Recommendation Report for Planning Permission for Works or Extension to a Dwelling

REF NO: BR/123/21/HH

LOCATION: 112 Victoria Drive
Bognor Regis
PO21 2EJ

PROPOSAL: Erection of side and rear extension following demolition of existing conservatory.

Proposed South Elevation

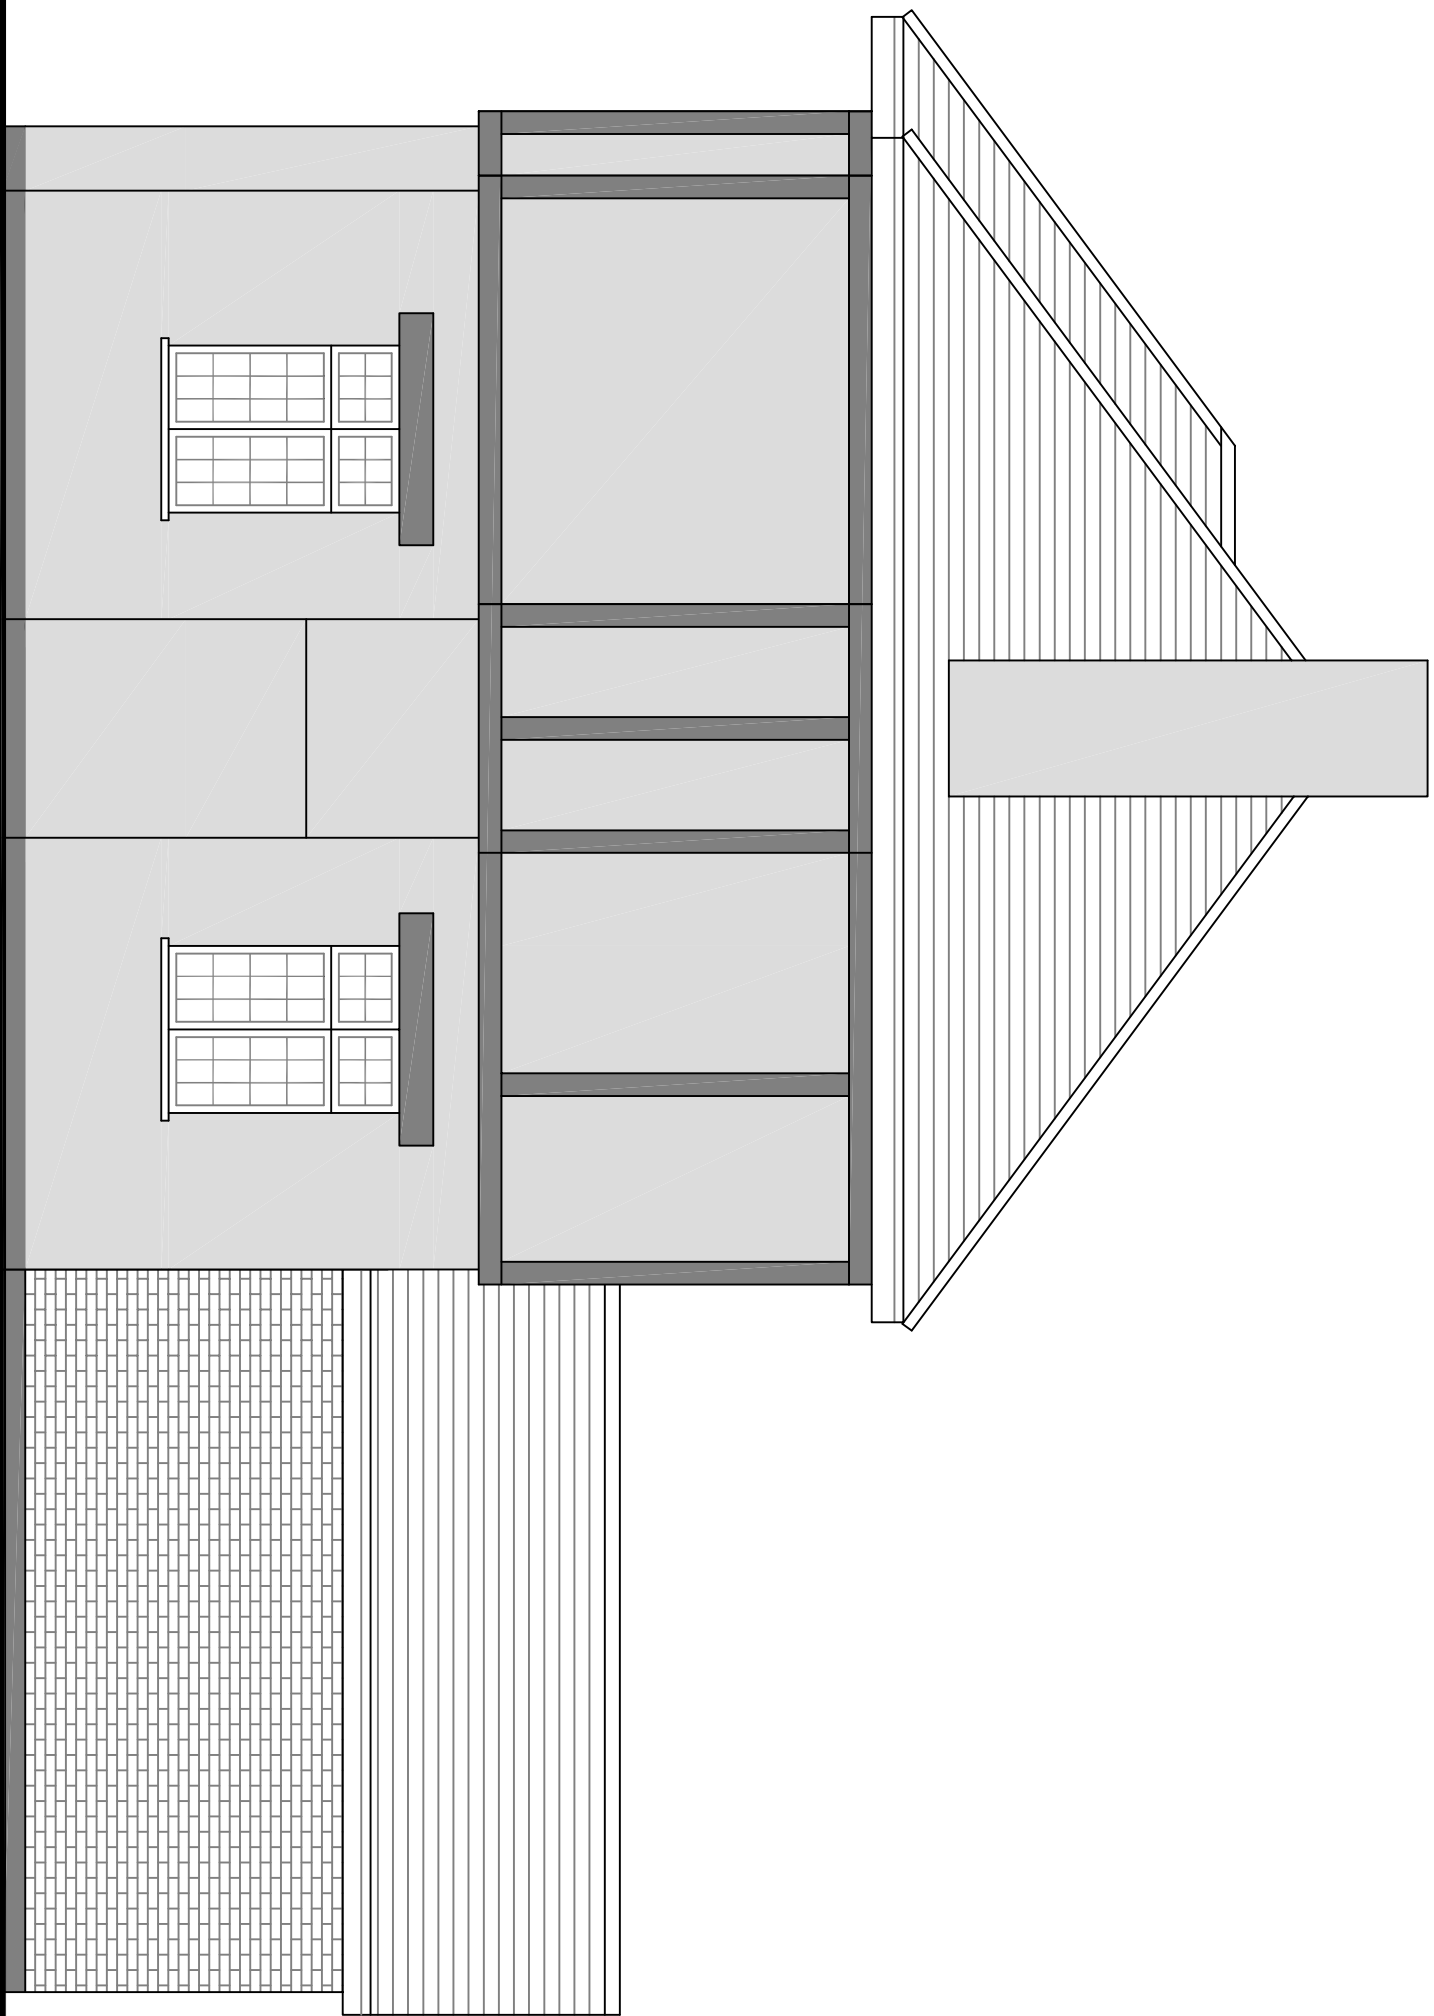
The side extensions measures 1.12m wide, 7m deep and 6m high approx.

The single storey rear extension measures 4.09m max level, 2.22m eaves level, 4.74m depth and 4.14m wide approx.

The proposed side extension would be built in flush with the main dwelling and roof profile would be integrated within the existing roof profile. The fenestration pattern would also match the host dwelling. The extension has limited width and does not extend across the width of the plot and over 1m distance from the boundary is maintained. Overall the extension would blend in within the architectural composition of the main house and appears to subordinate to the main house.

Class M of the design guide encourages the side extension to be set back from the main house and also gap should be maintained from the boundary to avoid any terracing effect. In this case extension is broadly aligned with the design guide, due to the detached nature of plot the extension would not cause terracing effect. The single storey rear extension in terms of design and scale is considered to be in keeping with the character of the host dwelling. As mentioned in the design guide the single storey extensions have lessor impact on the street scene, in this case the rear extension would not be visible from the public domain.

The single storey rear extension measures approximately 4.74m in depth and this contradicts with design guide class M. The existing extension on the boundary approximately measures 3.80m; therefore additional increase by 95cm in not going to significantly alter the existing situation. Also due to the detached nature of the plot, the proposed rear extension is not going to have significant impact in terms of overbearing, loss of outlook or loss of light. The two storey side extension does not extend across the full width of the plot, hence the distance is maintained from boundary; therefore the extension does not appear to have any detrimental impact on the adjoining property. The fenestration pattern does not cause any overlooking into the habitable areas of the adjoining dwelling.
